**Case Officer:** Linda Griffiths

**Recommendation:** Approve

**Applicant:** David Wilson Homes (Mercia) Limited And Gladman Developments

**Proposal:** Reserved matters to 15/01326/OUT - Layout, scale, appearance and landscaping for the residential development of up to 280 dwellings and 34 space car park.

Figure 4: Proposed diverted route for Footpath 120/49/10

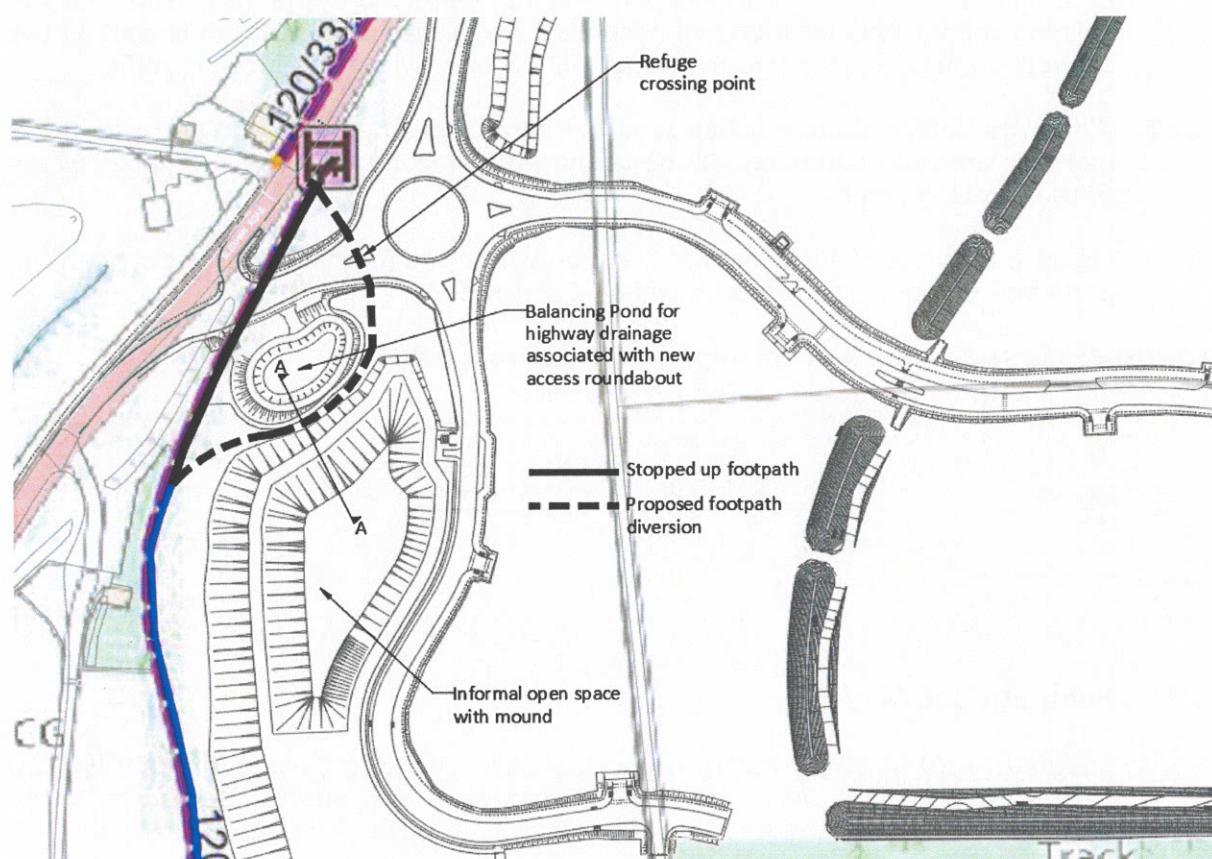
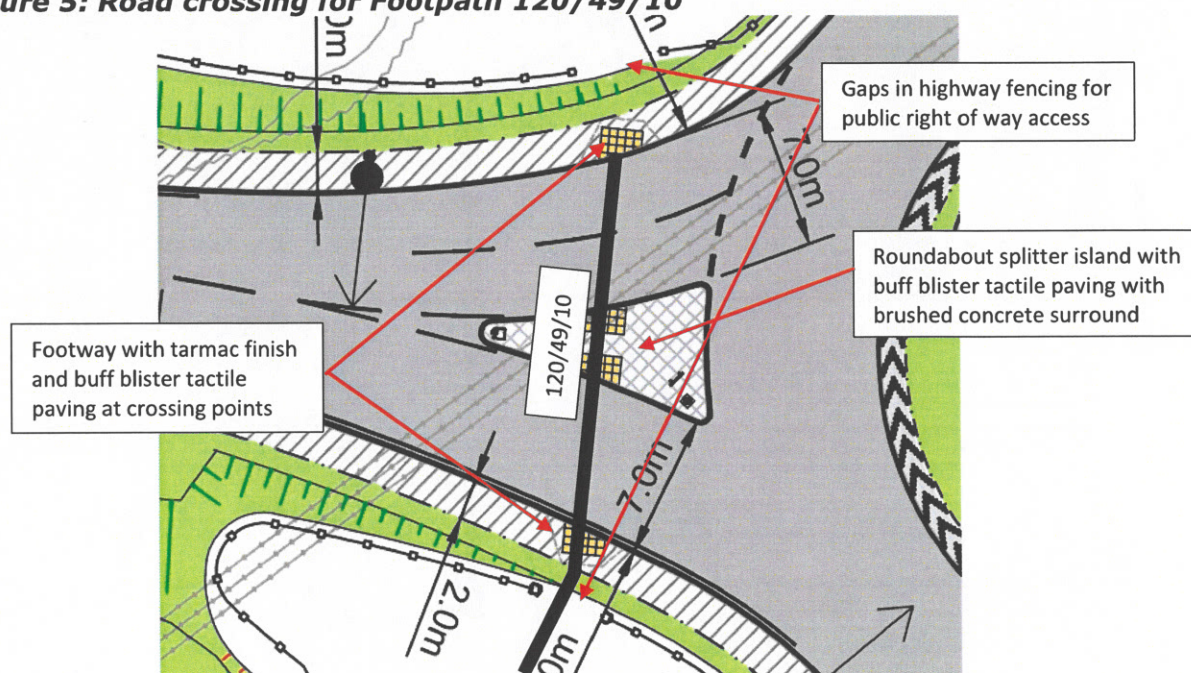
- 6.4. OXFORDSHIRE COUNTY COUNCIL – RIGHTS OF WAY (initial response): **Comments** - it is not clear if there will be a signalised Pegasus type crossing of main street where the footpath and new bridleway is being provided. Given that this is a traffic free path, it is important that non-motorised users are able to use it safely. It is also not clear what legal mechanism is proposed to create the new bridleway and whether this route will be managed in perpetuity alongside other green
